Recommendation Report for Planning Permission for Works or Extension to a Dwelling**REF NO:** EP/141/14/HH**LOCATION:** 34 Tamarisk Way
East Preston**PROPOSAL:** Re-building following major fire damage. Proposed works to include rebuilding of first floor & roof including new plain clay tile roof finish instead of the previous thatched roof finish. Resubmission of EP/97/14/HH.**SITE AND SURROUNDINGS**

South Elevation
scale 1:100

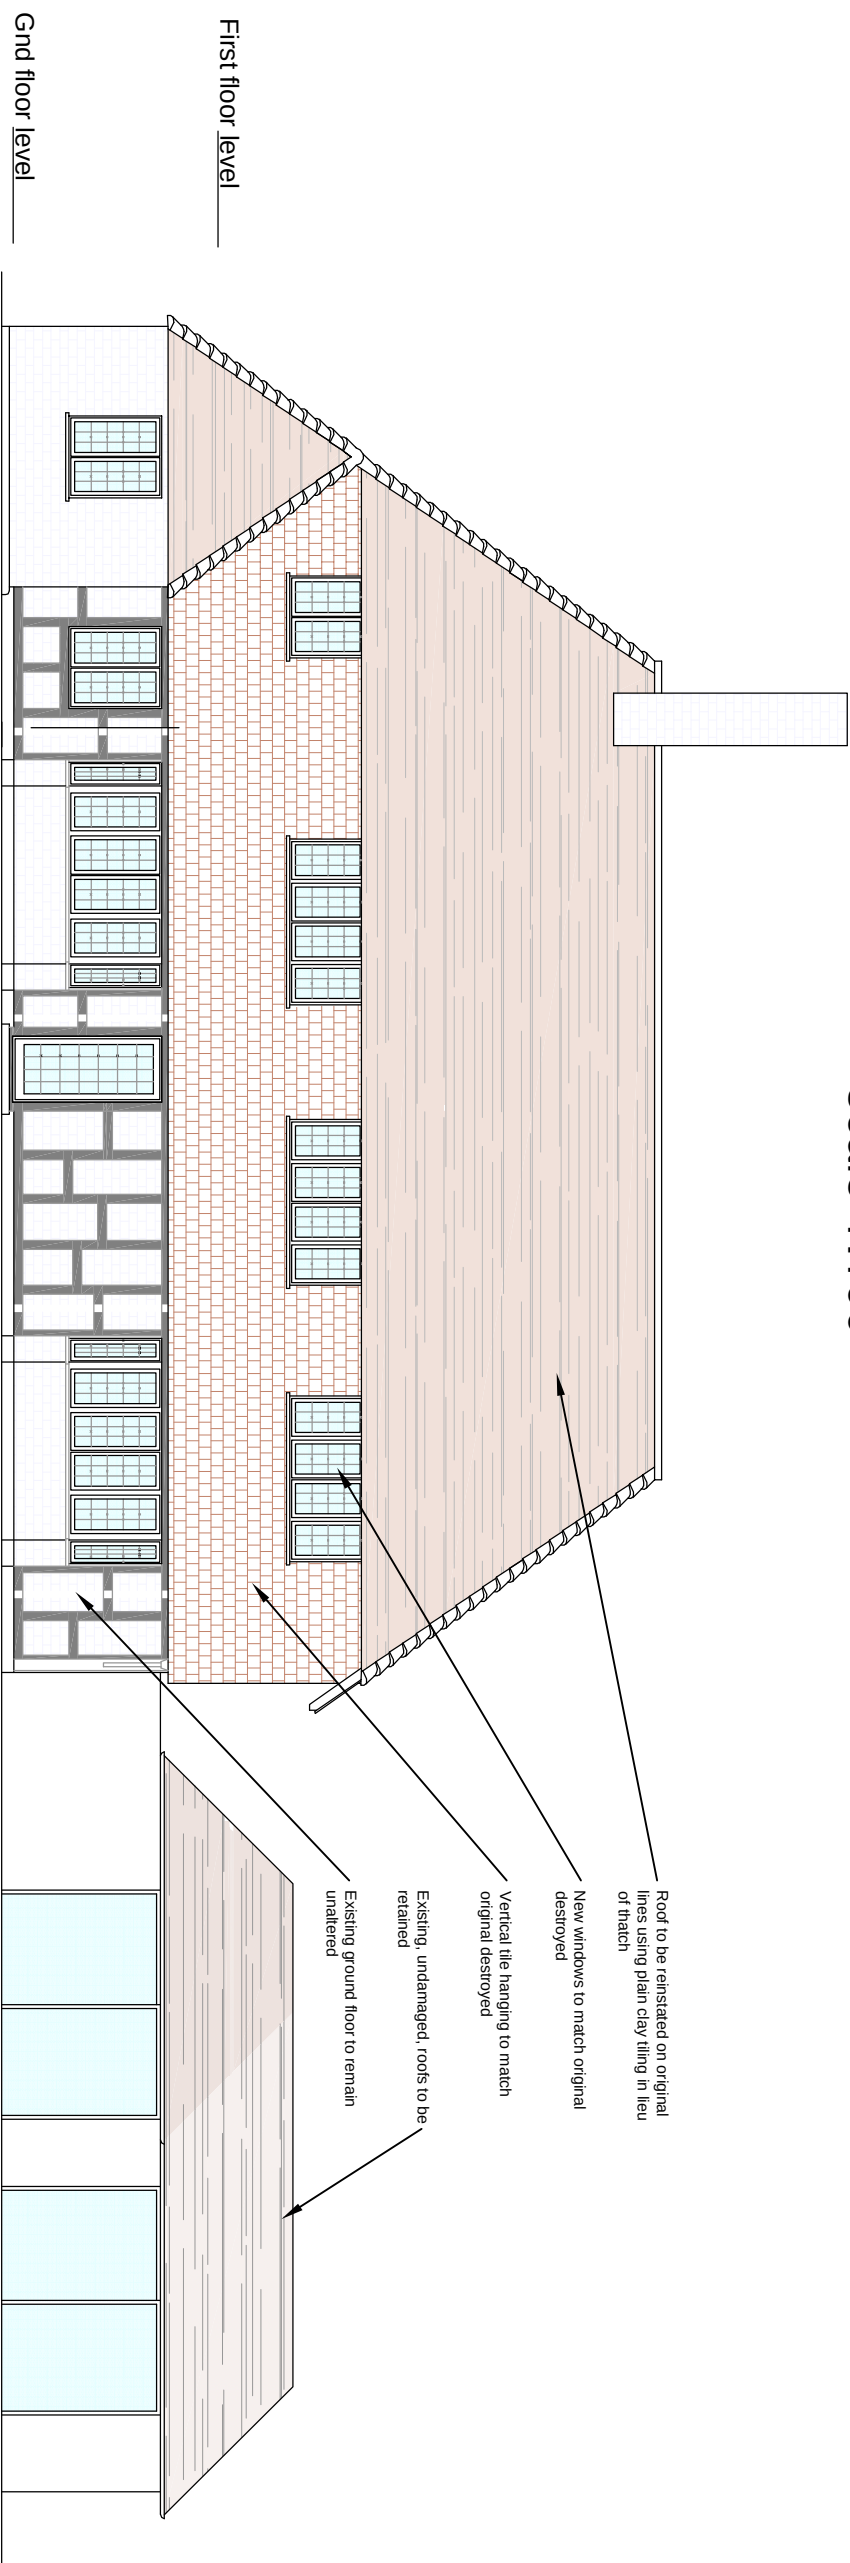
The relative close proximity of the property to the northern and eastern boundaries has already been established by the previous building, the ground floor of which still remains. The 3no. dormers on the side (east) elevation substitute windows in previous positions and the additional 1no. dormer on the side (west) elevation is comparatively small and maintains an acceptable separation distance to the neighbouring property such that it will not cause any harmful overshadowing or loss of privacy. There will be no harmful residential effects on no. 2 West Ridings (Mardon Hall) due to re-establishing a similar form and spatial relationship as the former property which includes an acceptable separation distance away from this neighbouring property.

West Elevation
scale 1:100

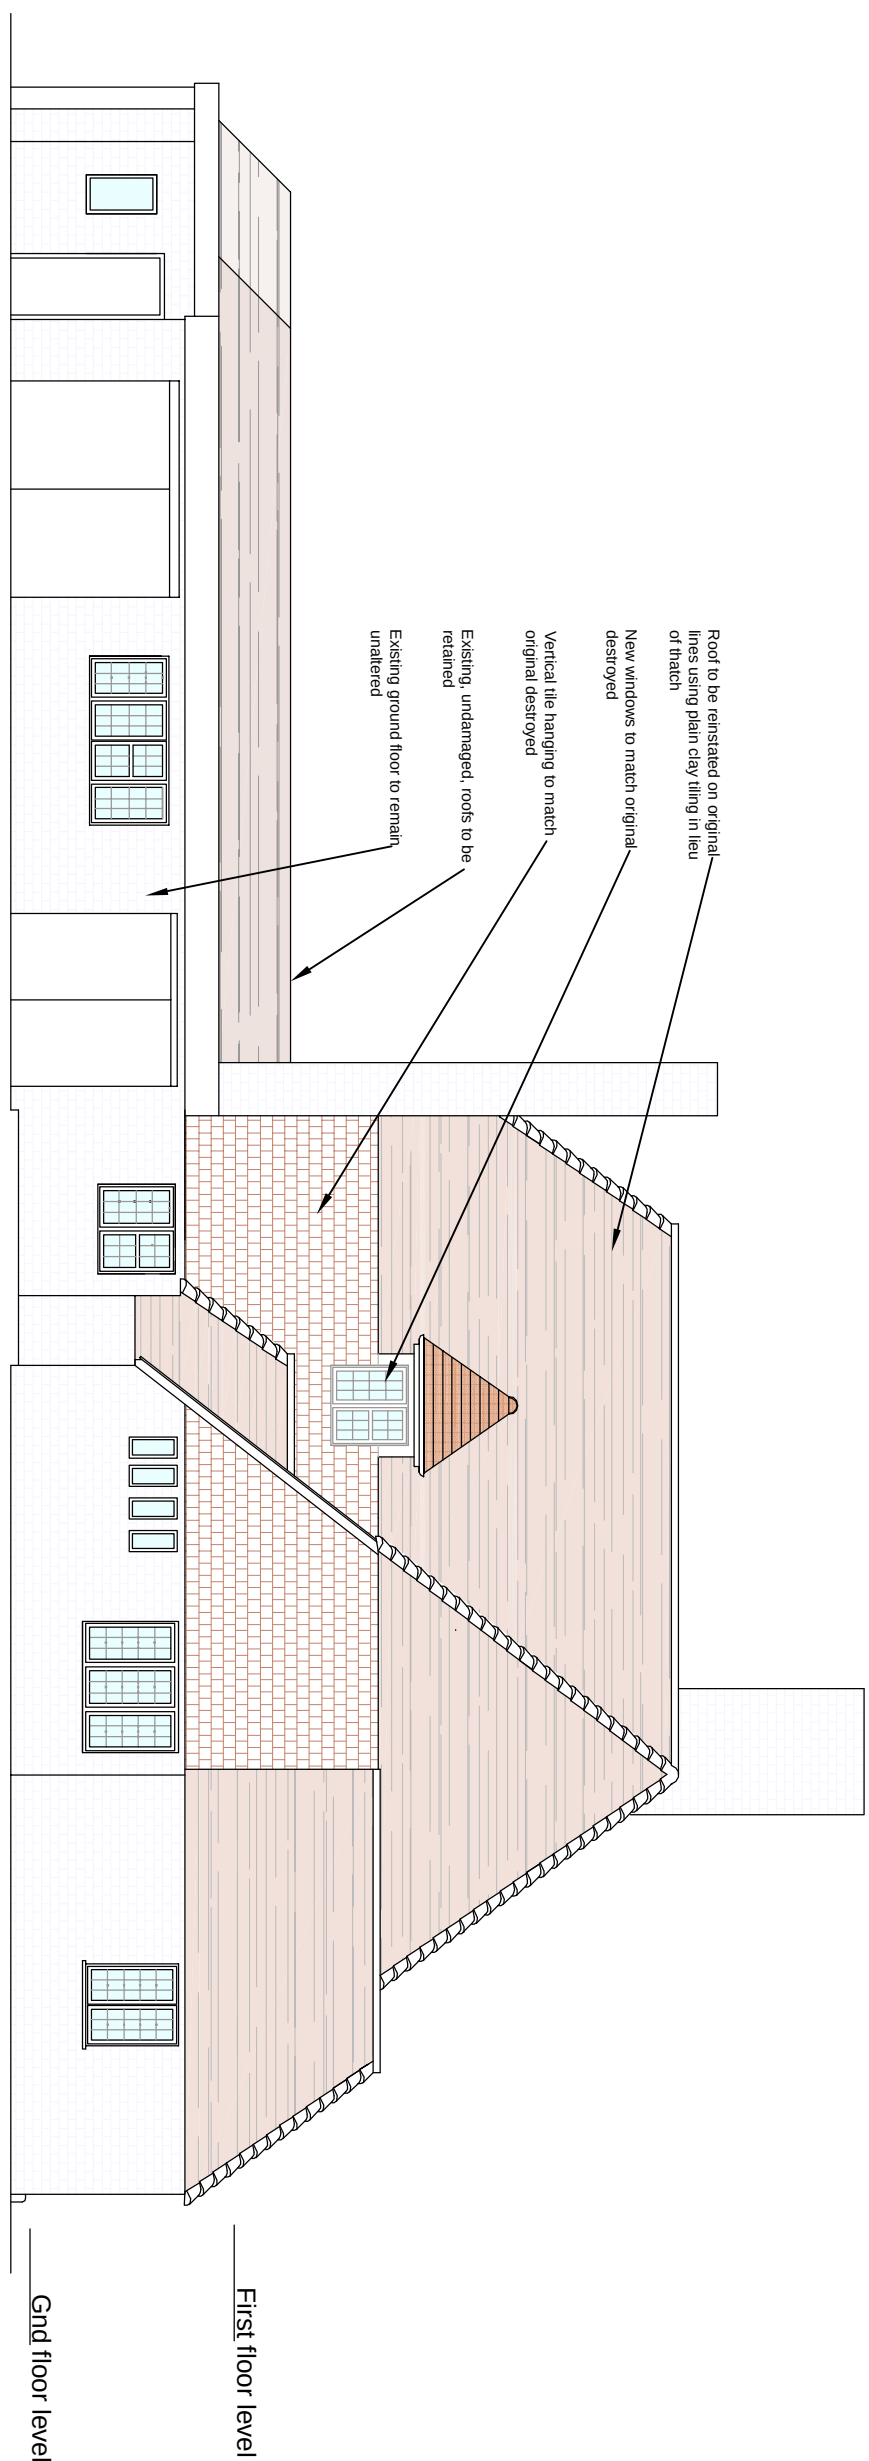
This application seeks planning permission to reinstate a fire damaged property which has resulted in the loss of the thatched roof and extensive damage at first floor level to leave the ground floor walls and a chimney largely intact. The principle difference between the previous property and the proposed is the change from a thatched roof to a plain clay tiled roof with 1no. additional dormer on the side (west) elevation.
